CITY OF ALBUQUERQUE

January 10, 2014

**Re: Montecito West Units 1 and 2
Grading and Drainage Plan and Drainage Report
Engineer's Stamp Date 1-06-14 (D09/D004)**

**MONTECITO WEST UNITS 1 & 2**  
**GRADING AND DRAINAGE PLAN**

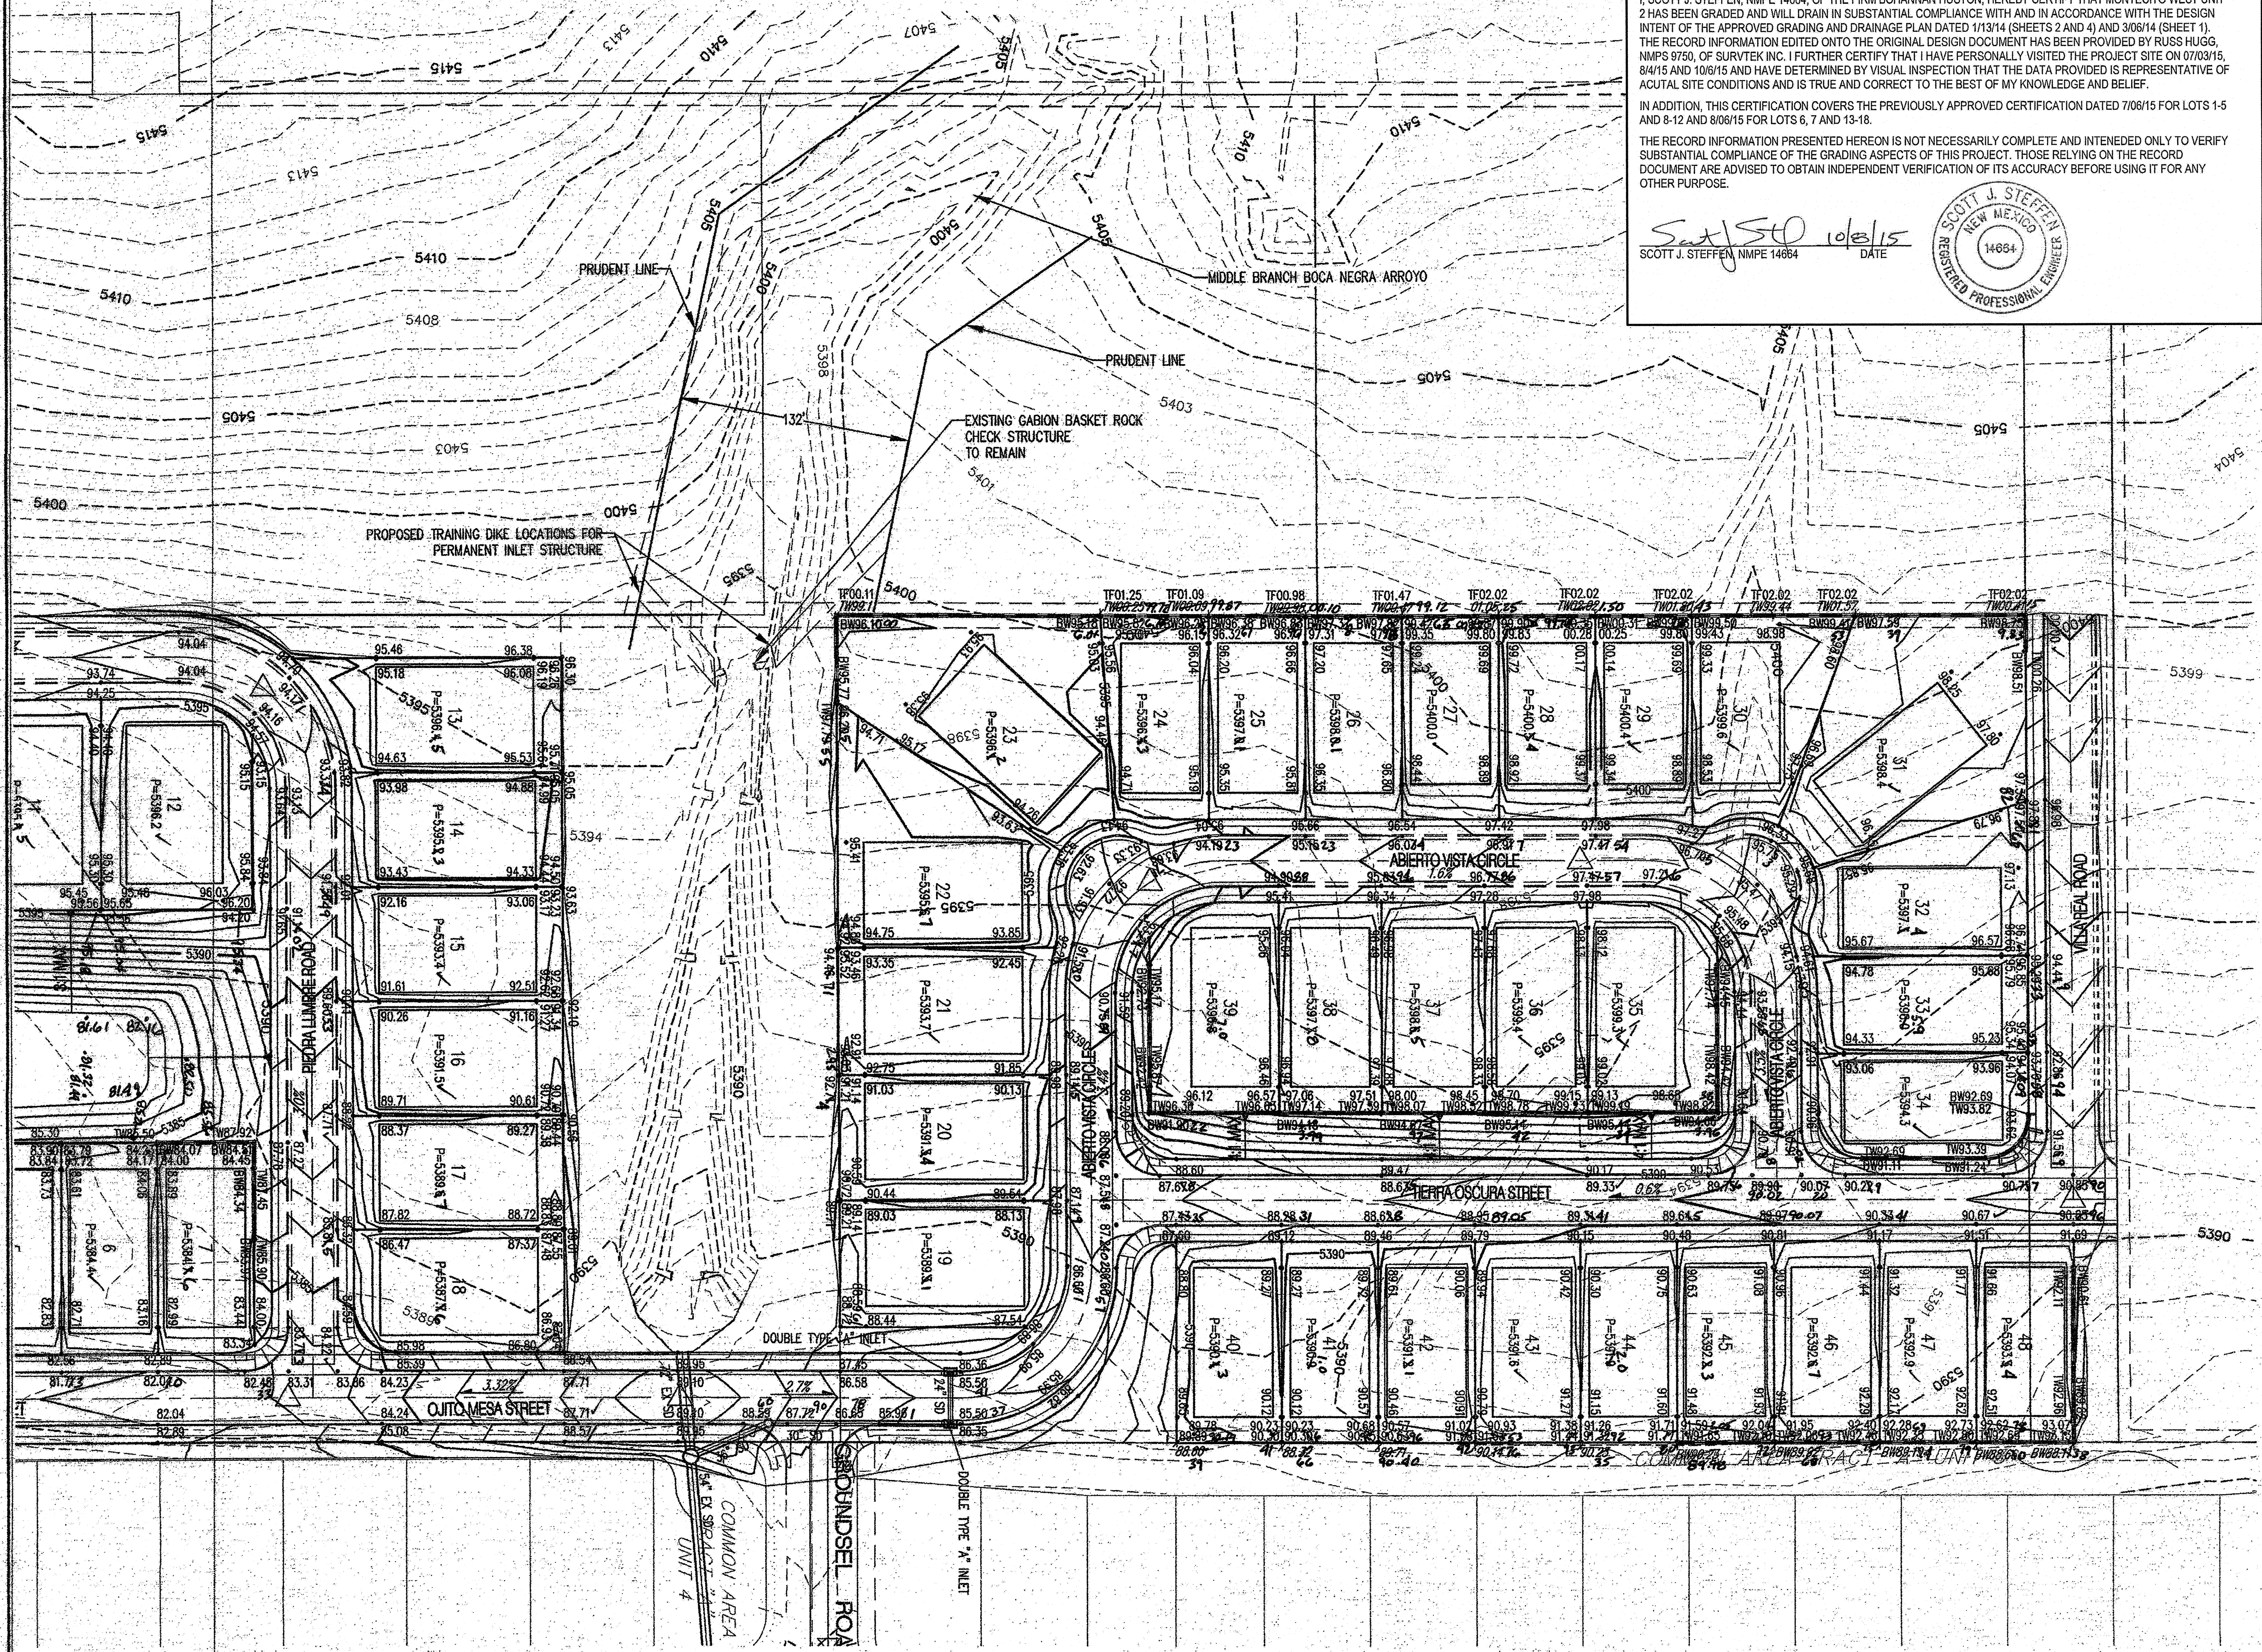
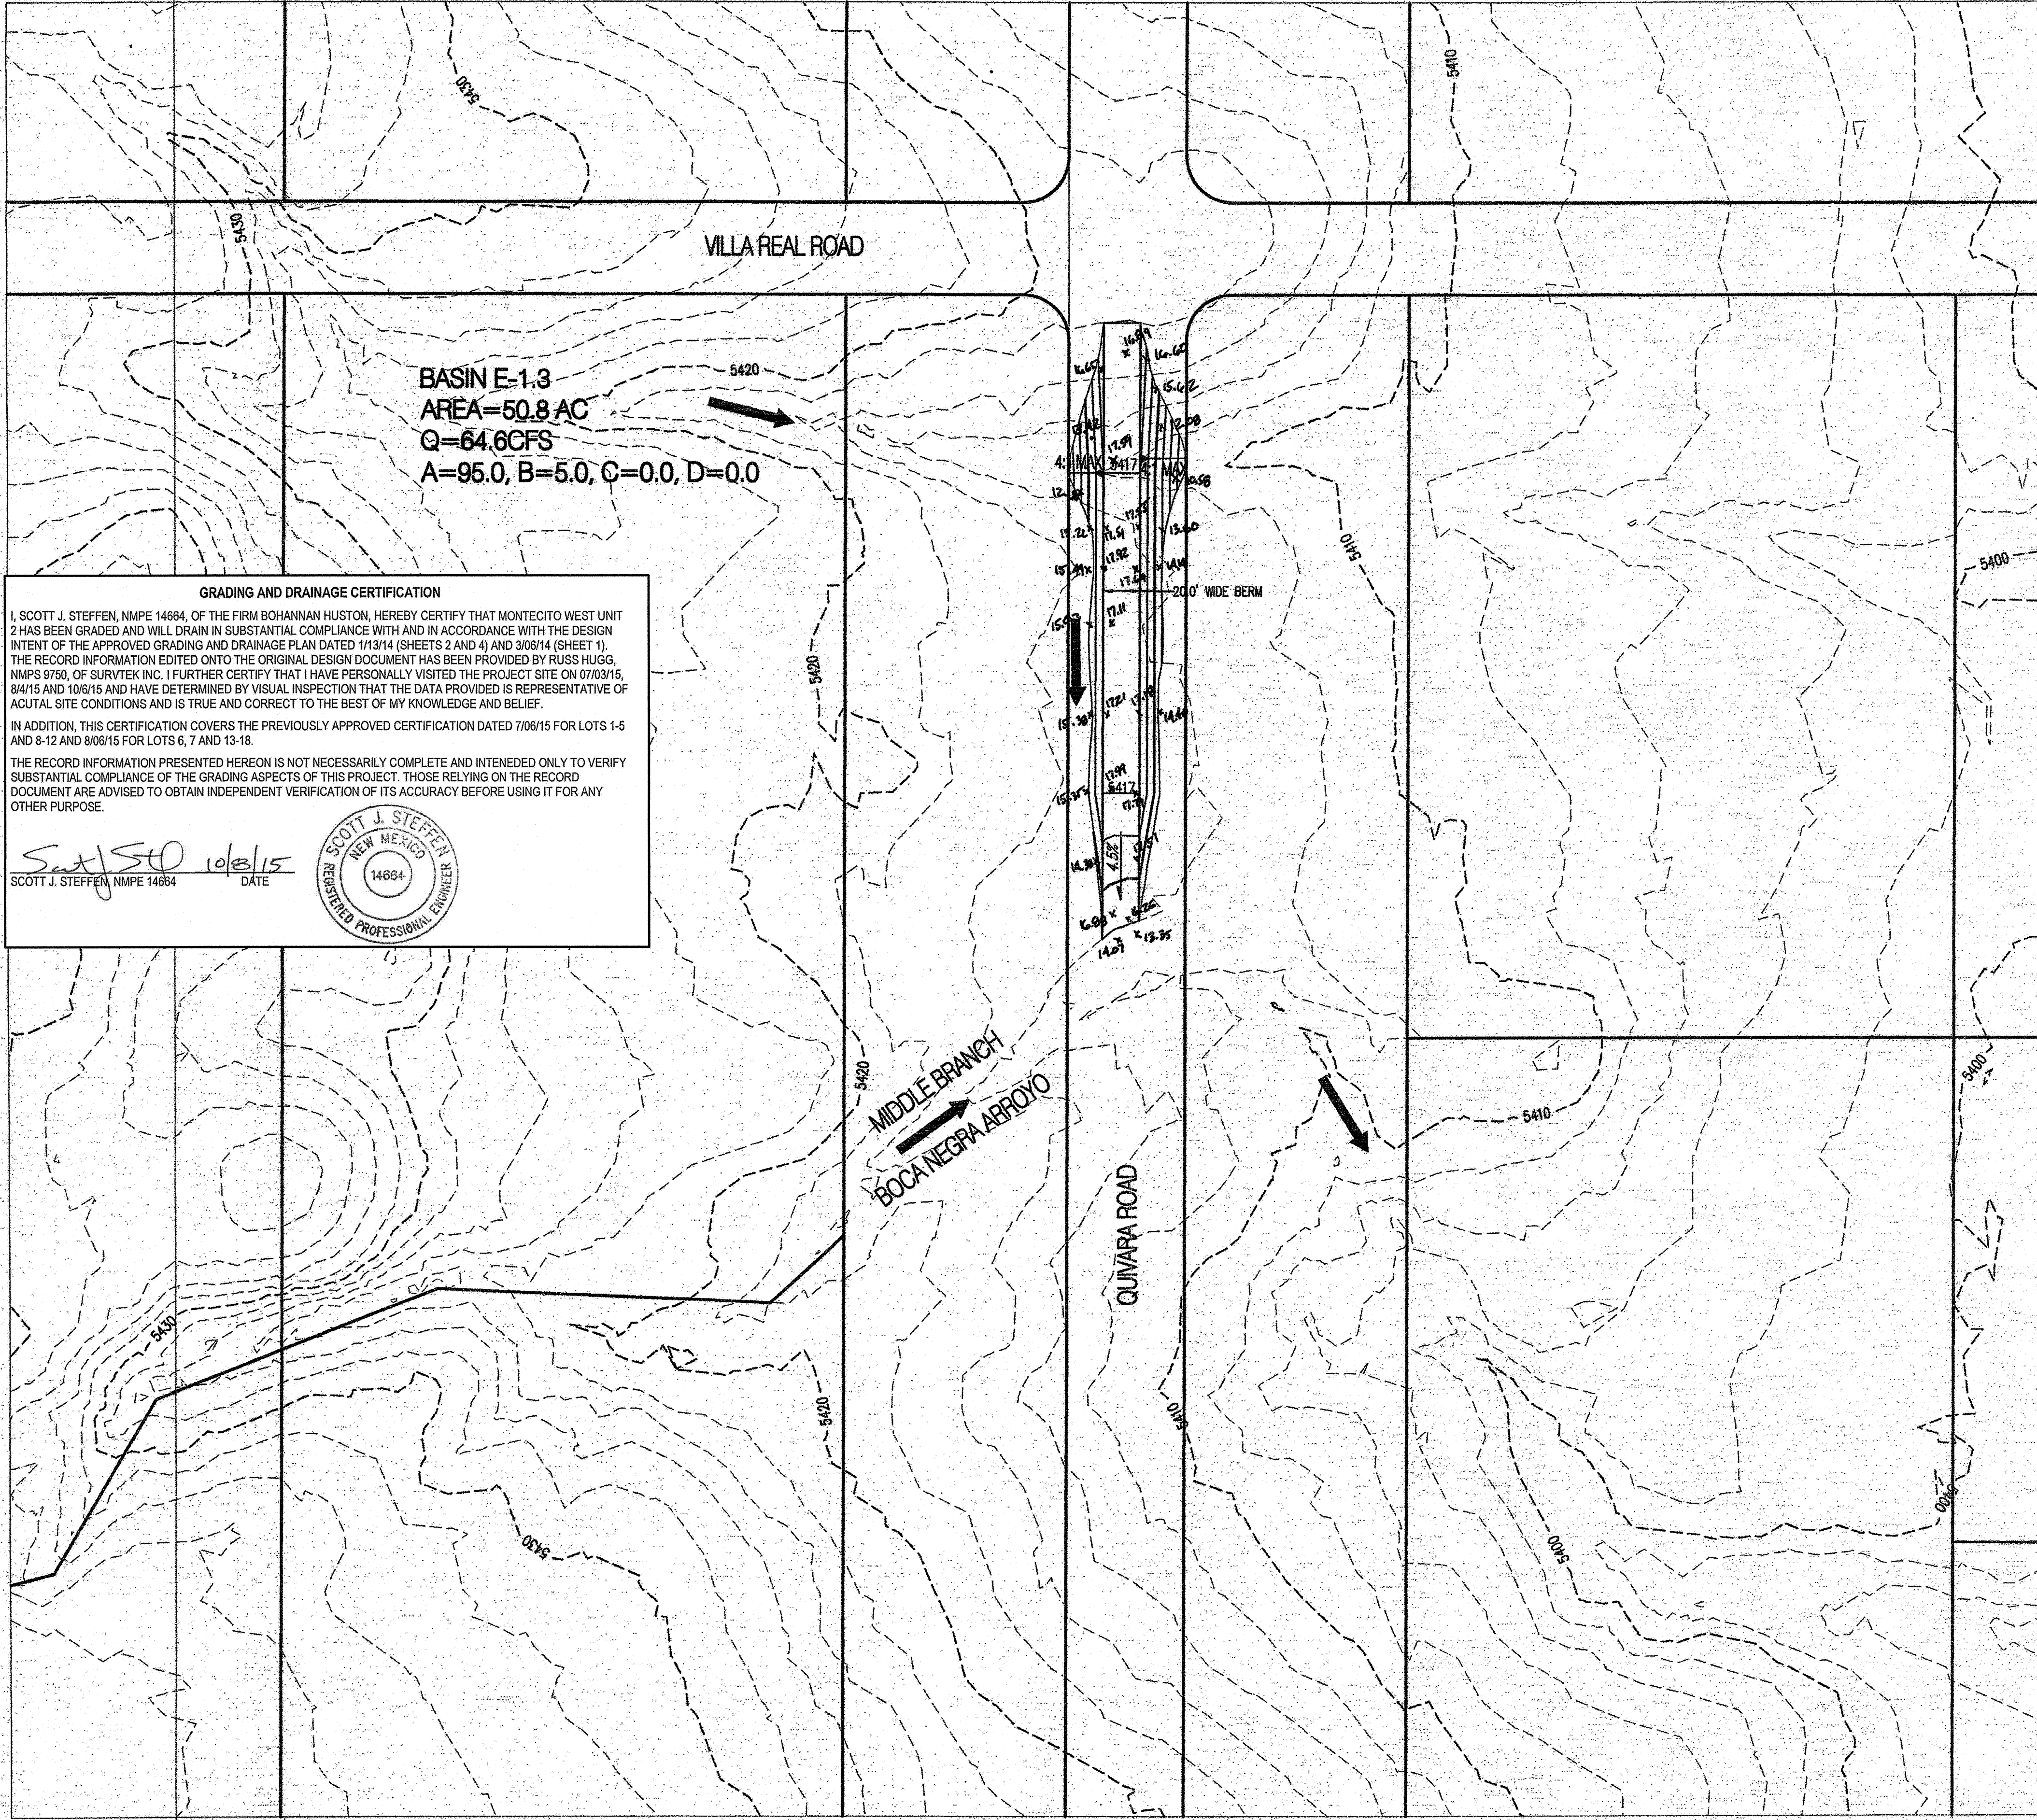
- 1) Please coordinate with Transportation for the construction of the proposed berm on Quivara Road. Double check the grading of the berm to assure runoff will drain to middle branch of the Boca Negra arroyo.

- 2) Grading within the utility easement west of lots 23 to 31 on the adjacent property is not acceptable. A floodwall should be constructed along the back of lots 29, 30 and 31 to allow runoff pond on the west side of the lots and then over flow to the north.

- 3) Extend Basin E-1.1 boundary to the existing subdivision to the east. Provide allowable flow rates for the Offsite Basin E based on existing storm drain capacity.

- 4) Clearly show all the retaining walls. Provide top and bottom of the wall elevations.
- 5) Will there be an offsite basin south of basin A-1.2 which would drain to Vista Vieja Ave. How will it impact this project?

- 6) Provide Storm pipe capacity calculations in the report.
- 7) Show the 100-year water surface elevation for the pond within Tract 1.
- 8) The 24" storm drain pipe between lots 38 and 39 should be maintain within Tract 4 .

- 9) Fix text overlaps.
- 10) Recorded Maintenance and Covenant agreements are required prior to Final Plat
- 11) approval. Any required offsite Drainage Easements must be recorded prior to Final Plat approval.
